From: <Robert_Rosadi@sta.nsw.gov.au>
To: "Kate MacDonald" <Kate.MacDonald@planning.nsw.gov.au>
Date: 8/31/2011 11:43 am
Subject: Re: MP 10_0171 - 330 Church Street Parramatta,
Attachments: Annexure 10 Traffic and Parking Assessment.pdf

Thank you for forwarding through the updated documents for the proposed development at 330 Church Street in Parramatta. I have reviewed the documents and would request that the following points be included in the assessment of the proposal;

PROJECT
RIVERFRONT APARTMENTS
330 CHURCH STREET
PARRAMATTA NSW
DRAWING NAME
Plan_Parking Level 01

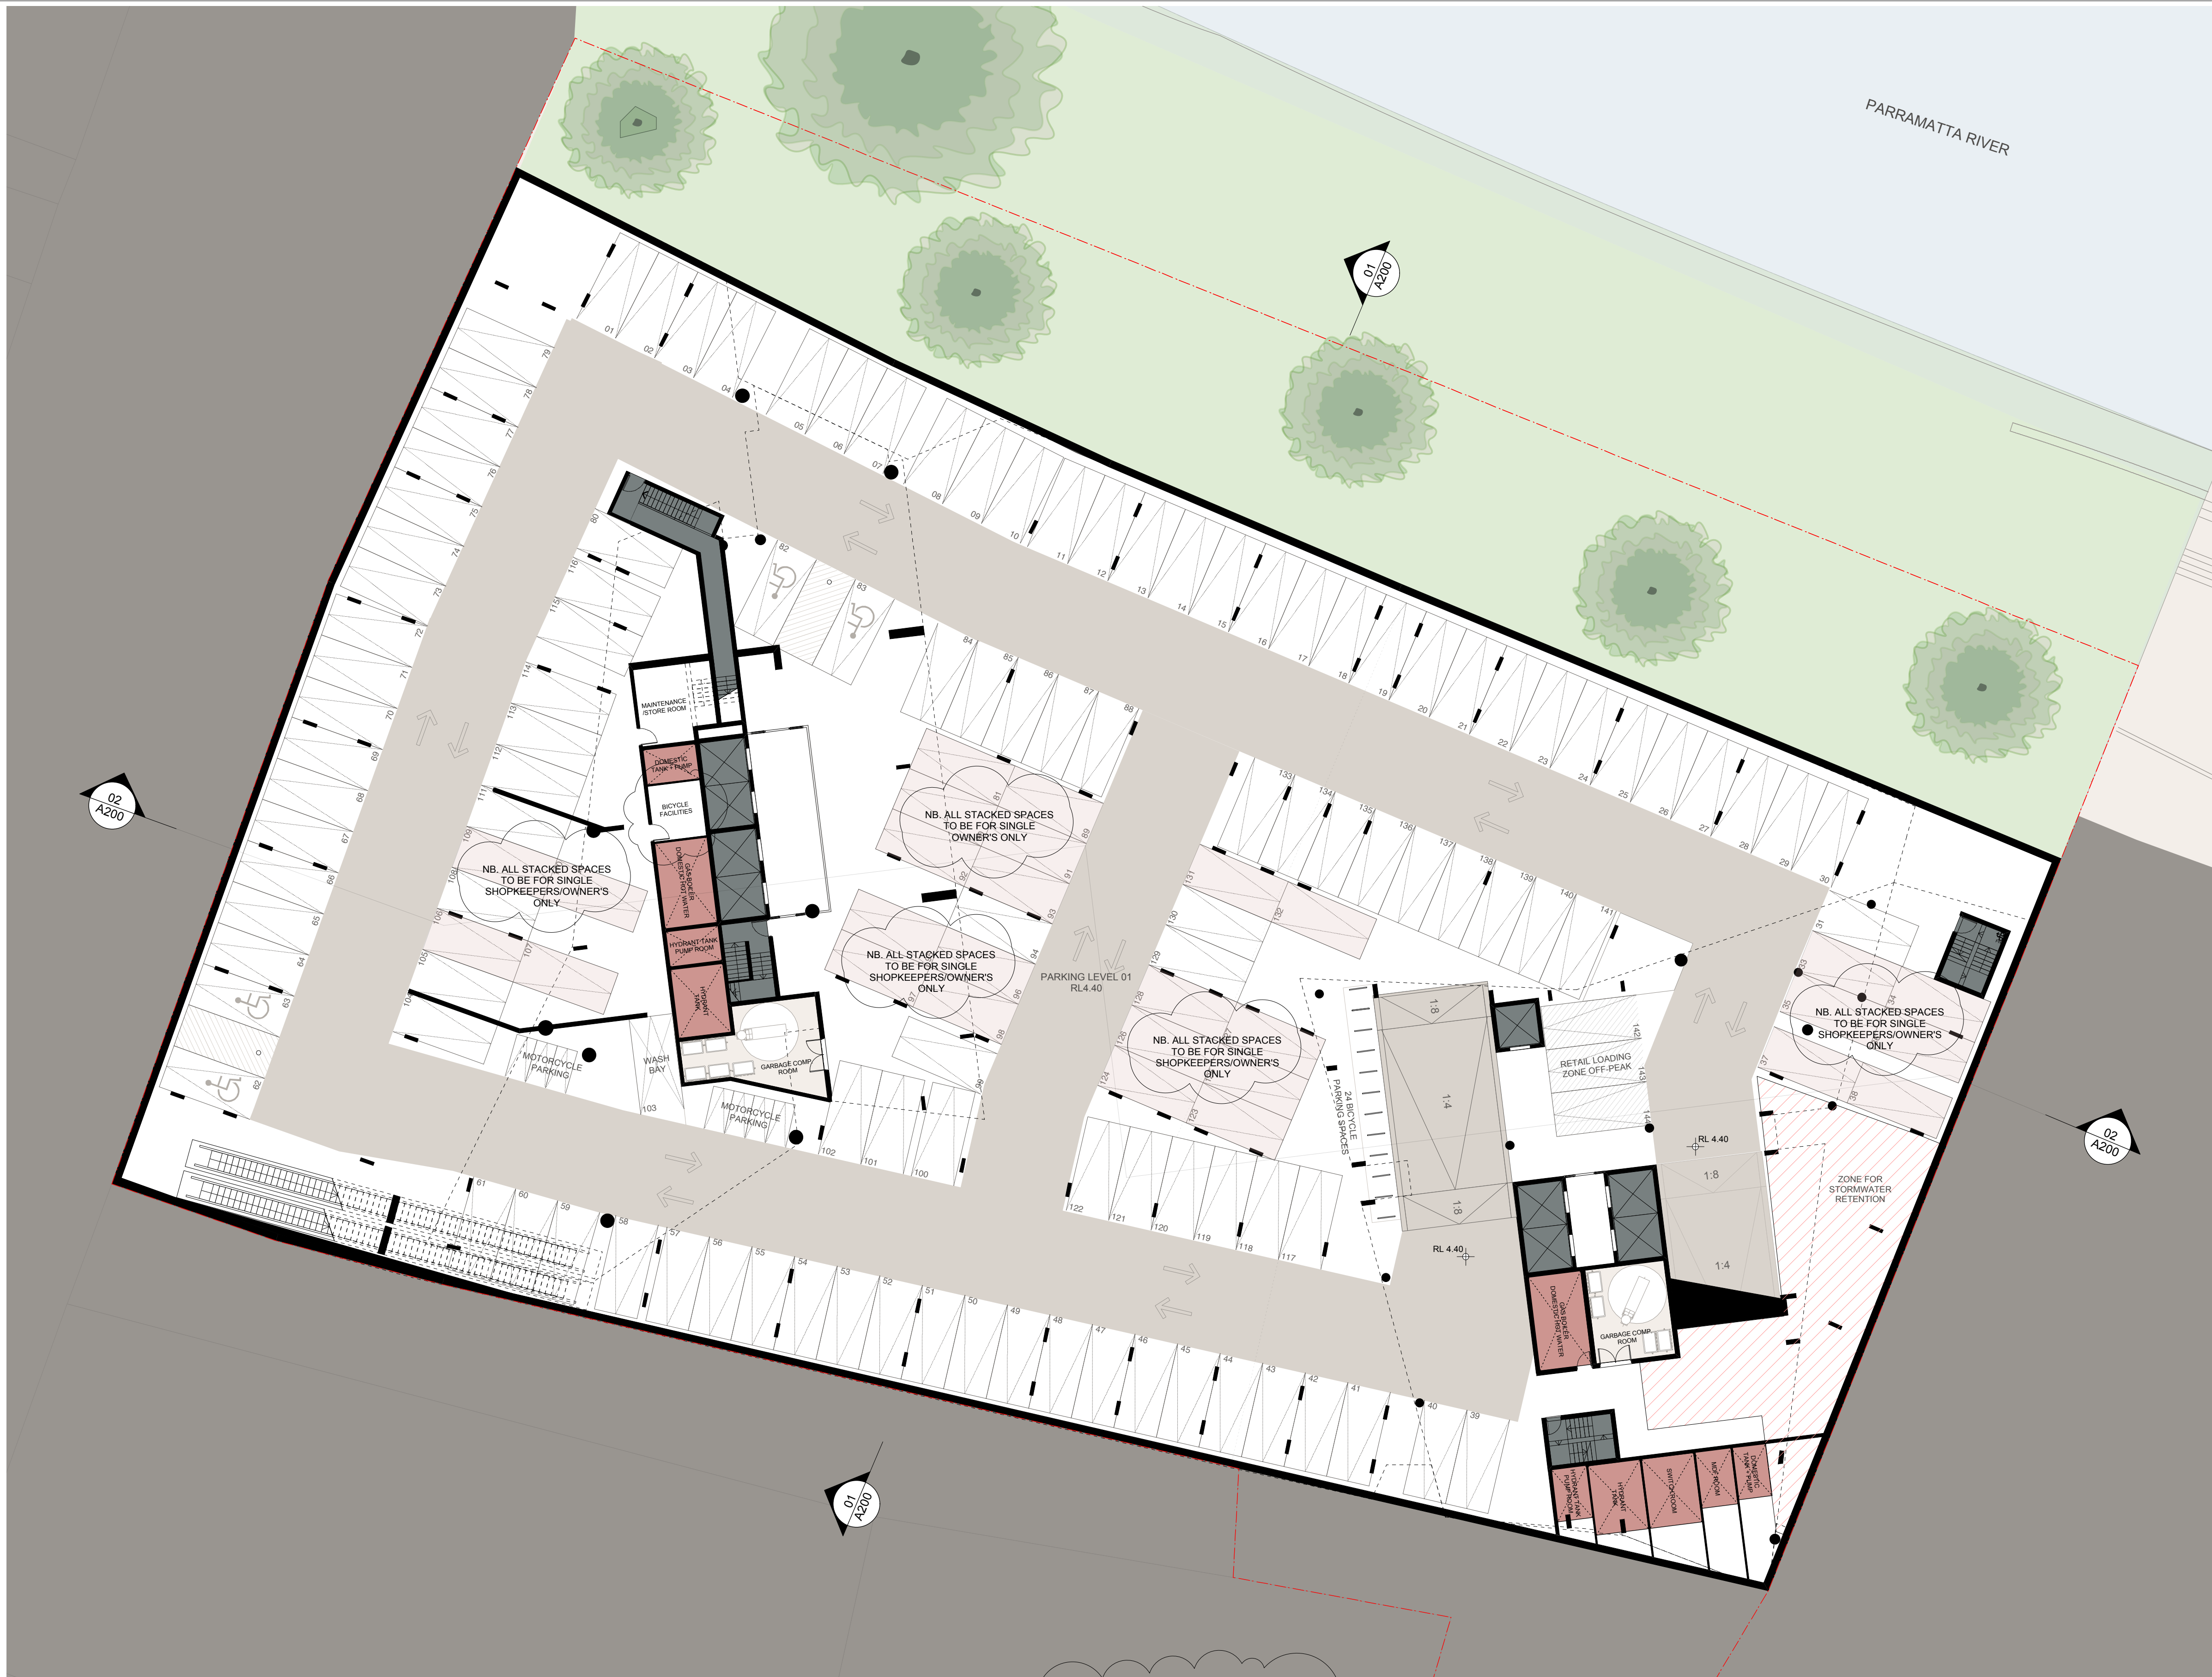
1. Section 4 of the Traffic and Parking Assessment outlines the LEP requirements for parking and the proposed allocations. The application of the LEP requirements would result in a need for 78 visitors spaces and 145 retain spaces, a total of 223 spaces. The proposed development has allocated 190 spaces for both visitors and commercial parking, 33 spaces less than the specified requirement.

While State Transit supports reduced off-street parking allocations for residential usages to encourage the use of public transport, sufficient parking must be provided to meet the expected demands generated by the retail usages. Insufficient retail parking provision often results in illegal parking on the public road, especially for small purchases that don't take a lot of time. Given there is a bus stop immediately adjacent to the site and parking demand on-street is high, if off-street parking is insufficient it is likely that illegal parking will occur within the bus zone which impacts on the safety of bus operations.
